PINS ref: EN010170

Application by Green Hill Solar Farm Ltd. for an Order granting Development Consent for a proposed solar development on land between Northampton and Wellingborough

CPRE Northamptonshire
Comments on DENZ questions and responses
Deadline: 29th September 2026

Title:  
Figure 16.4 BESS Fire Emissions Study Area,  
Receptors and Modelled BESS Locations

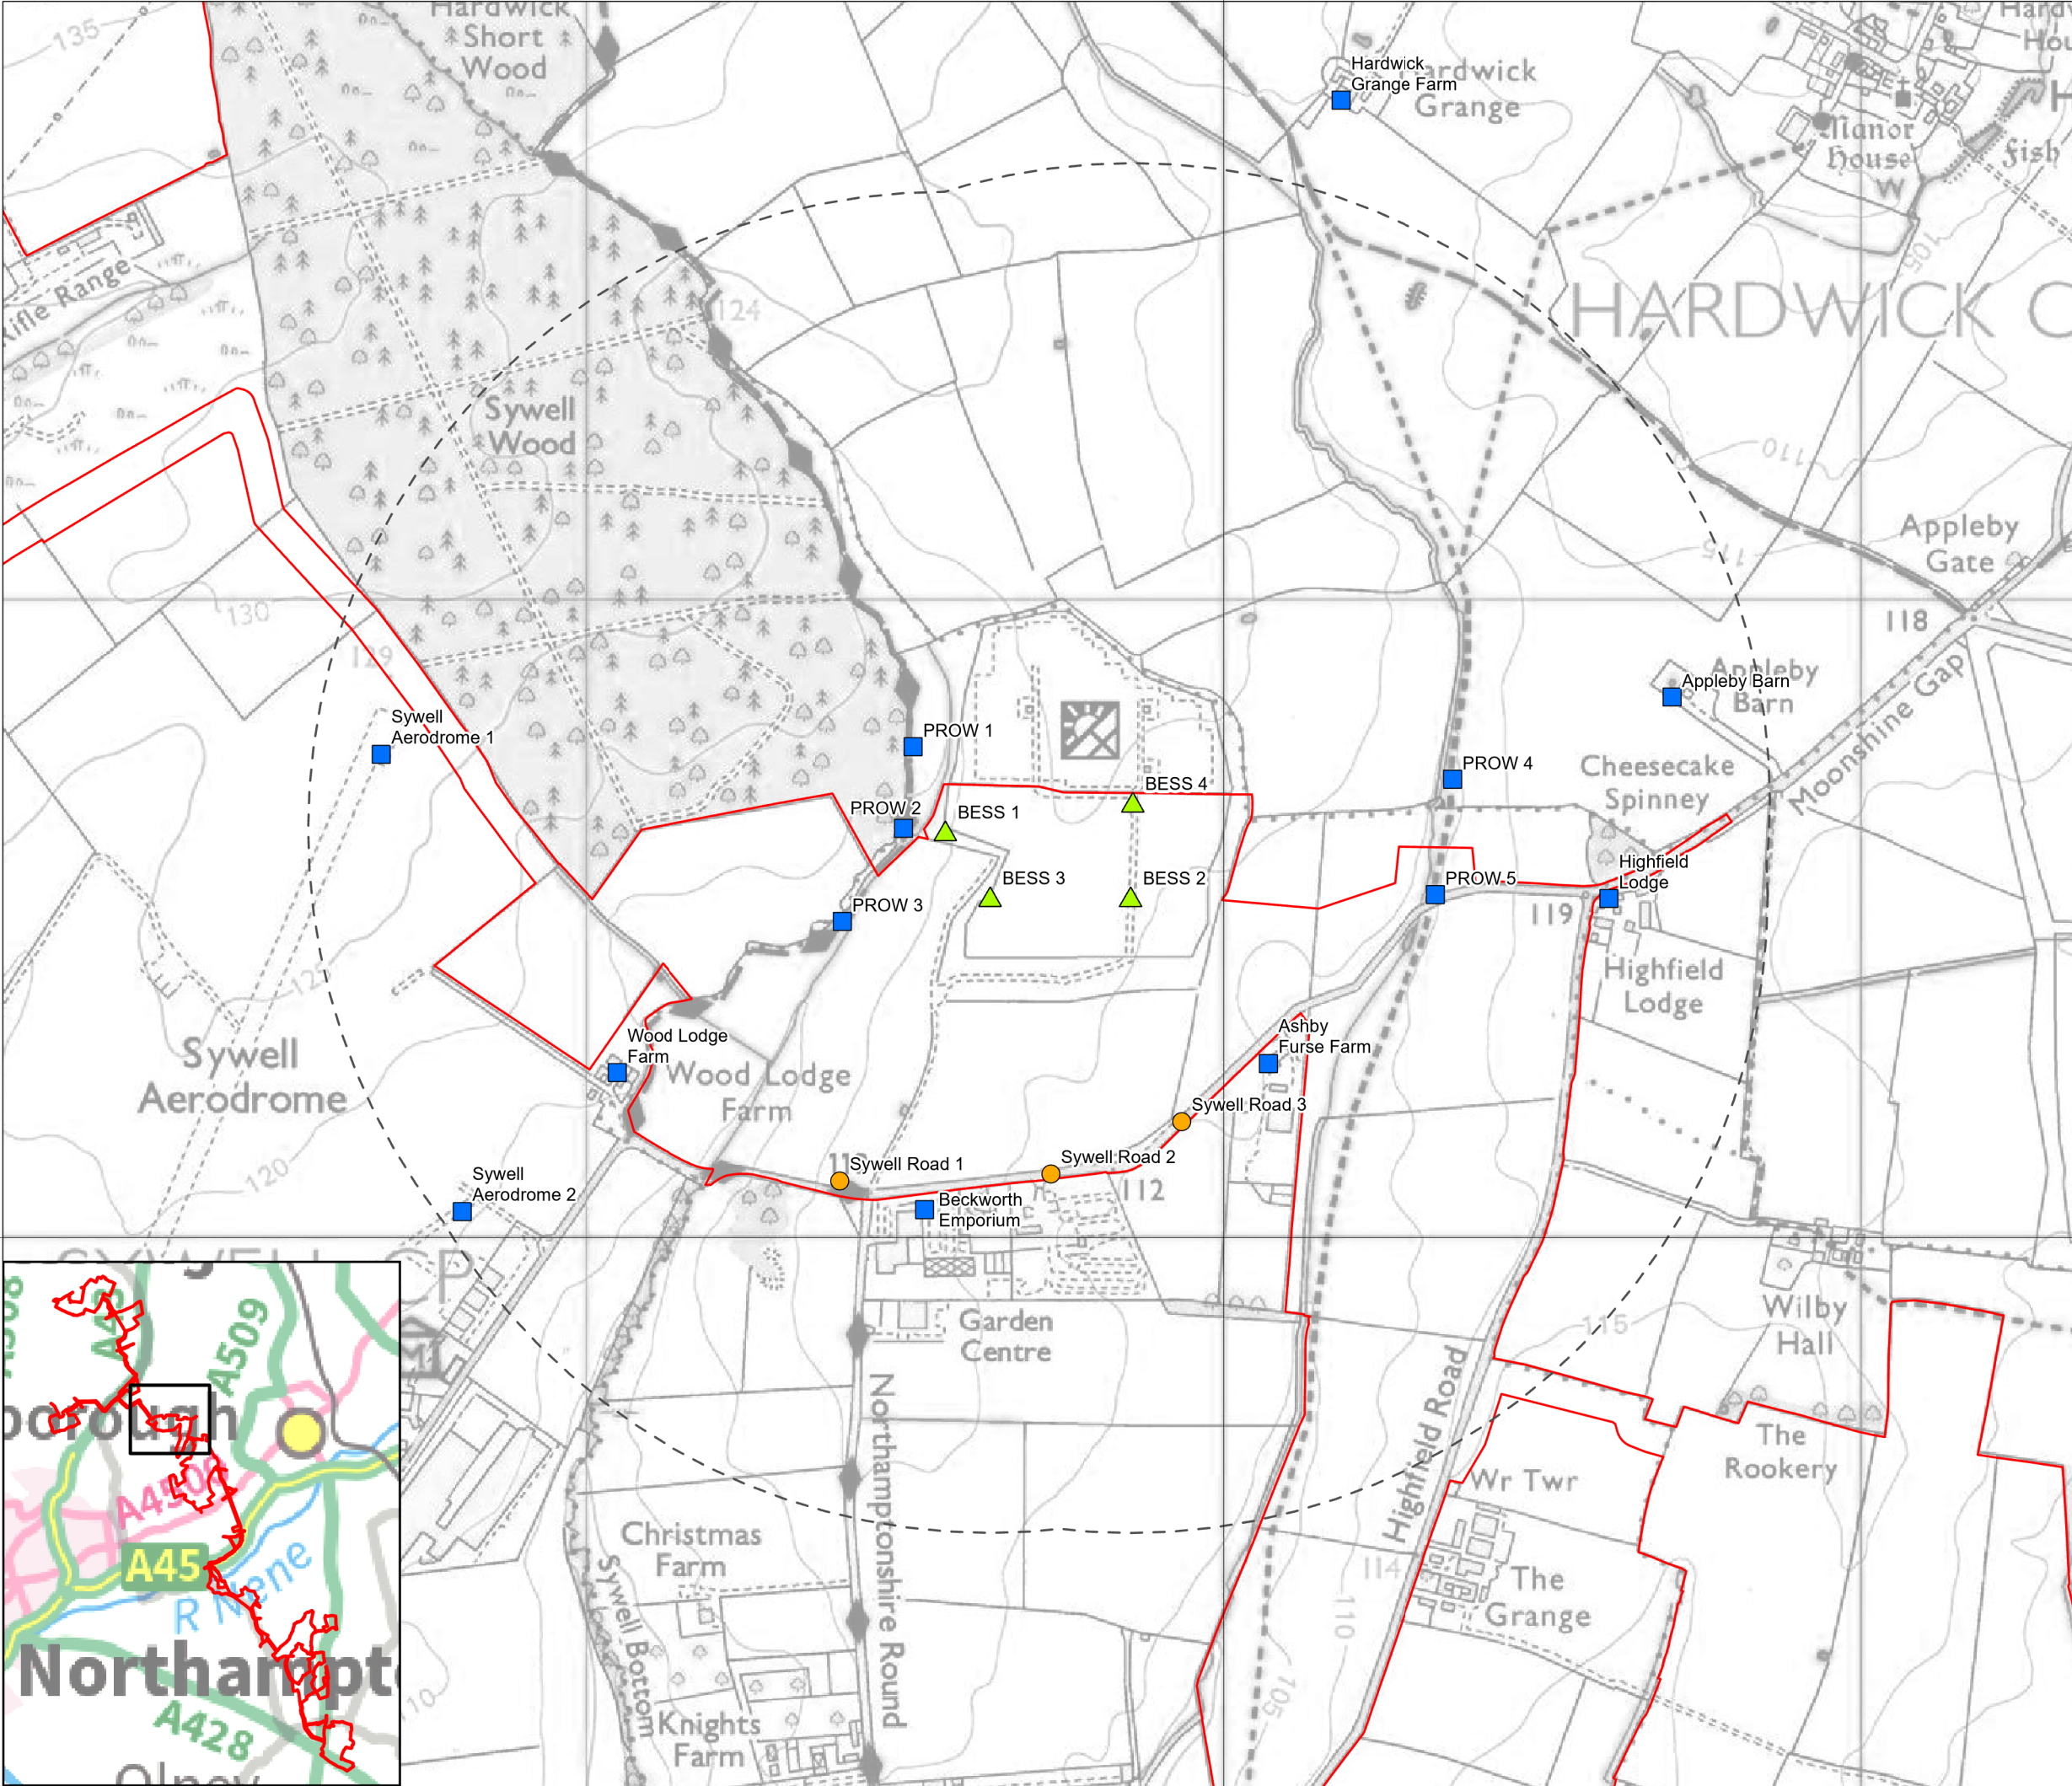
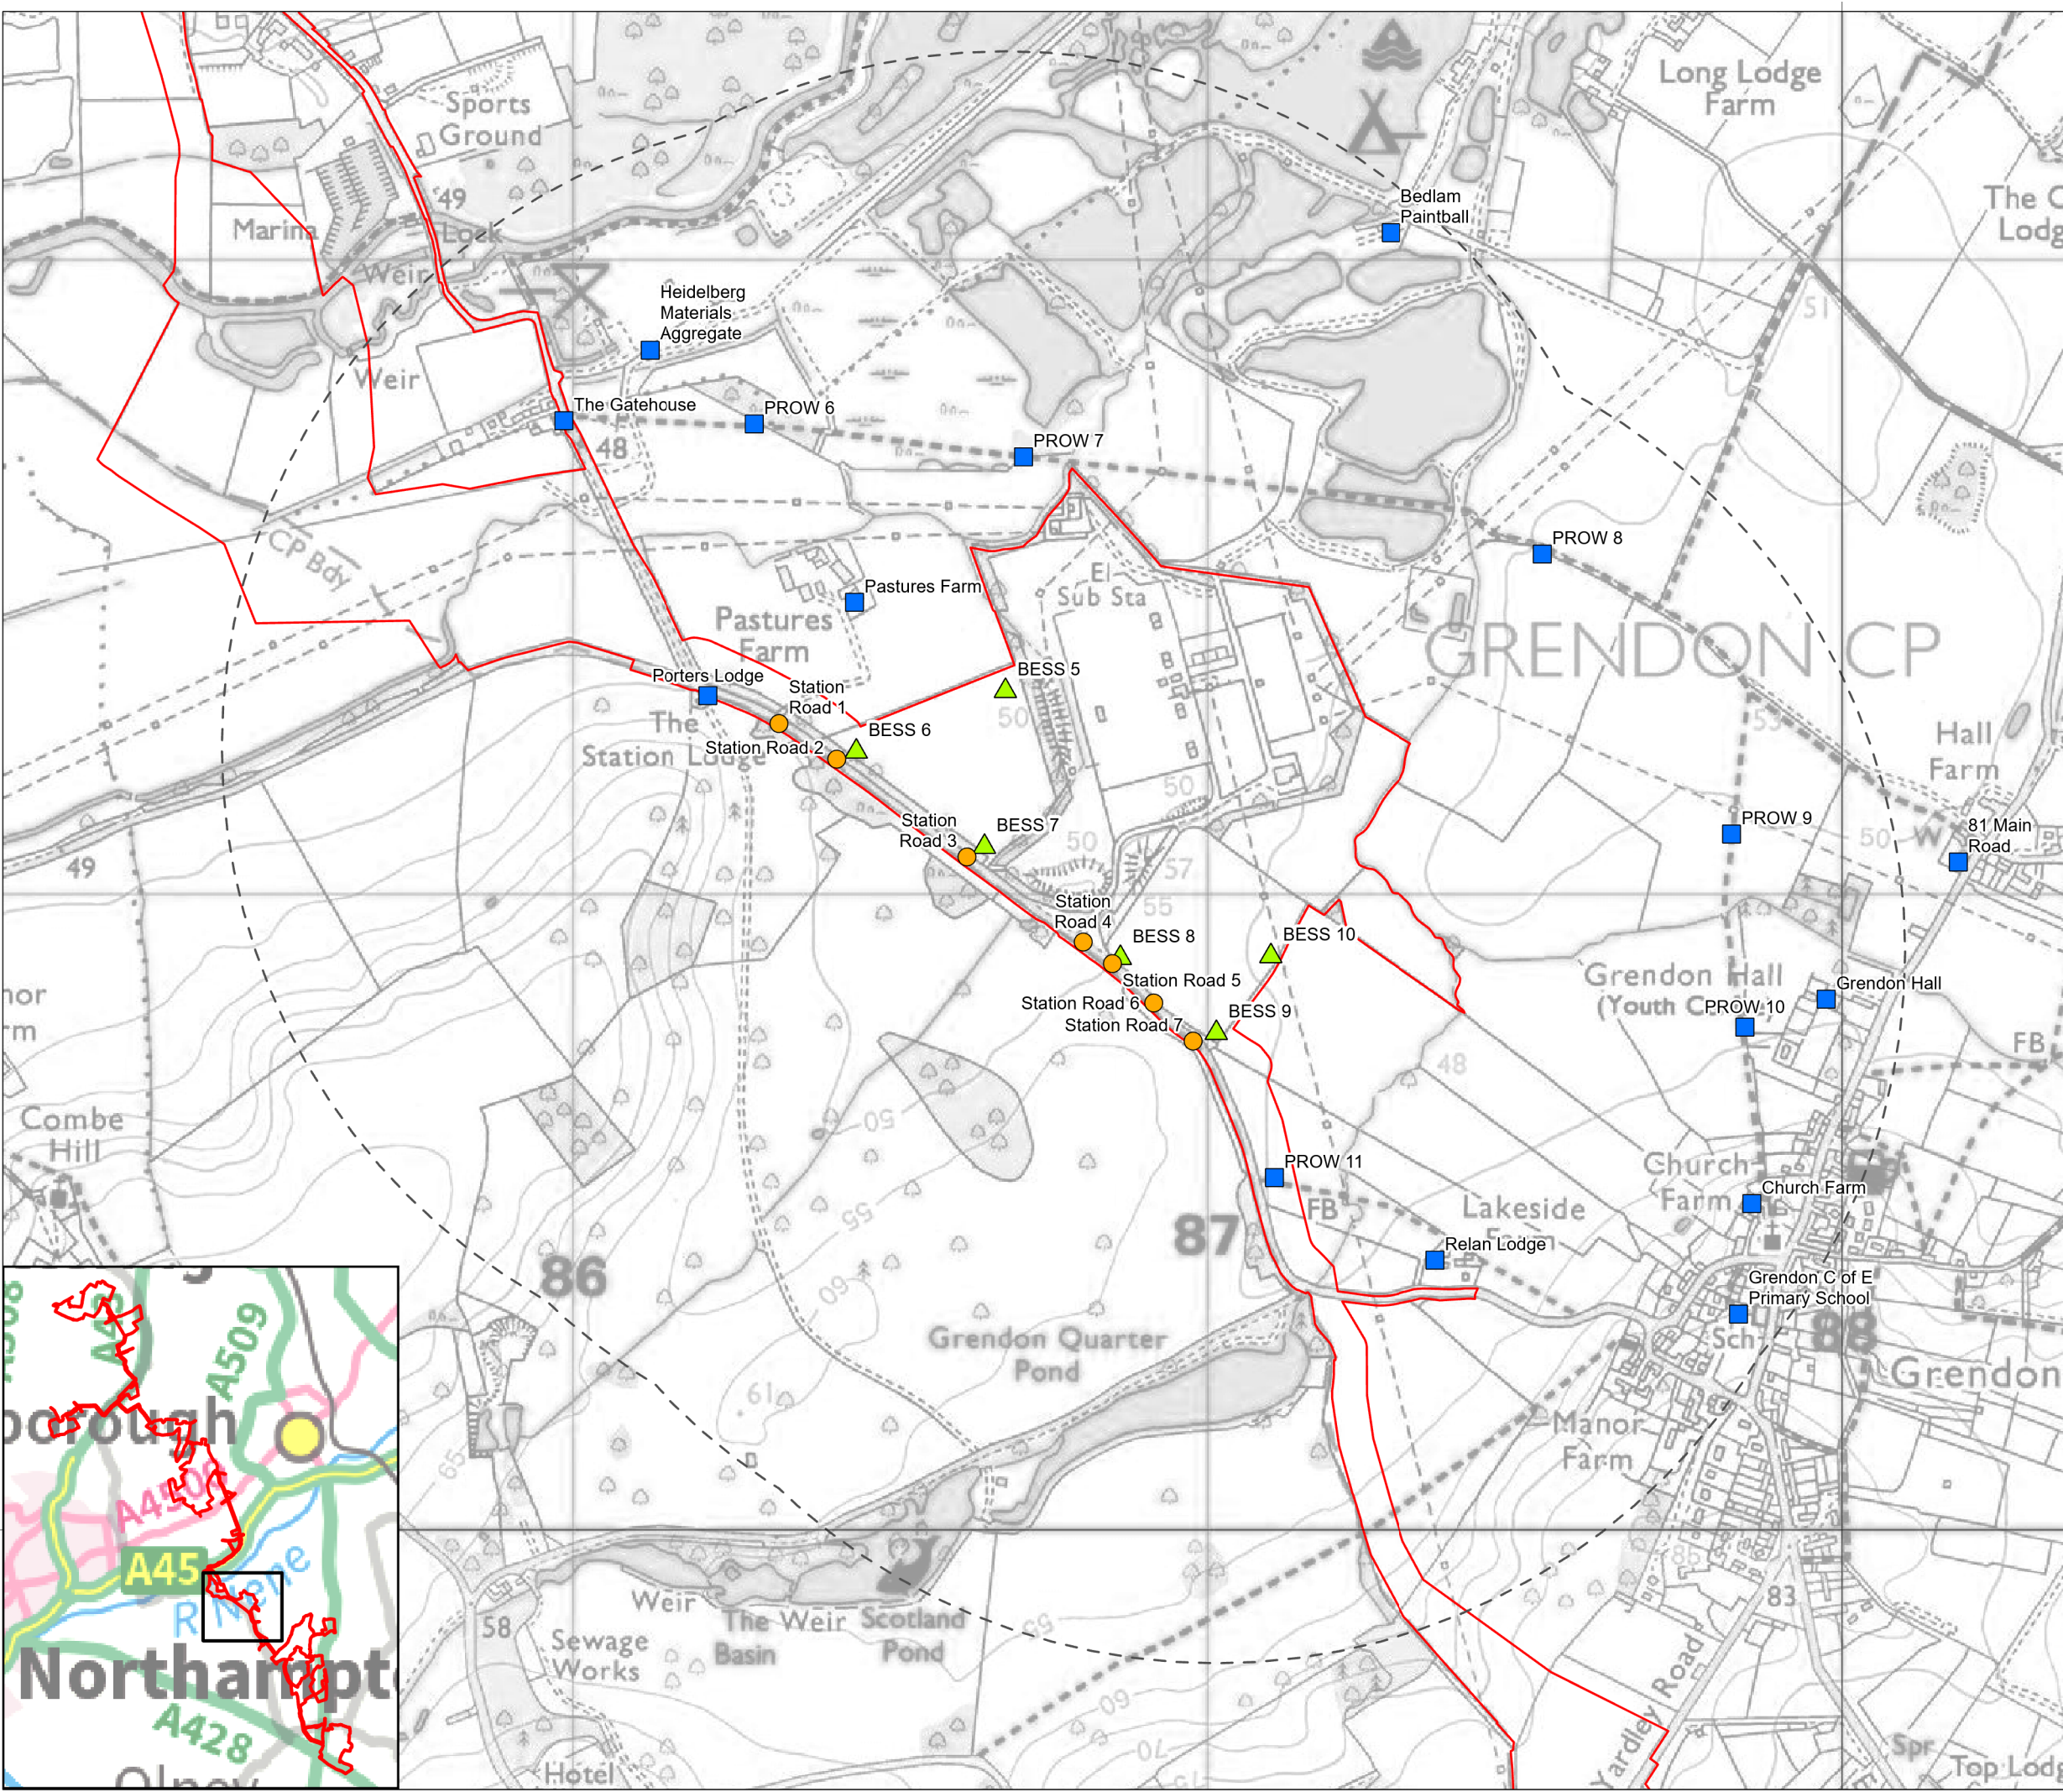
Returning to the specific point about the risk of pollution/contamination of the Upper Nene Valley Gravel Pits Special Protection Area and the Upper Nene Valley Ramsar Site, we questioned whether there was adequate capacity within the water retention reservoir to store the volume of contaminated water that would be generated during a battery fire. The proposed reservoir did not seem adequate to hold the runoff that would be generated by the many hours during which a battery would burn (72 hours in the case of the battery fire in Liverpool).

Furthermore, the toxic fumes generated during a fire were only assessed for a two-hour duration during normal weather conditions which is not consistent with the Rochdale Envelope approach. There was not an assessment of the build-up of toxic fumes that could occur when there was, for example, a temperature inversion when the fumes would not be dispersed by the wind. There was also no assessment of whether rain occurring at the same time as a fire would bring toxic water back to earth and into the catchment of the protected areas (another issue that we raised to which the applicant gave no response).
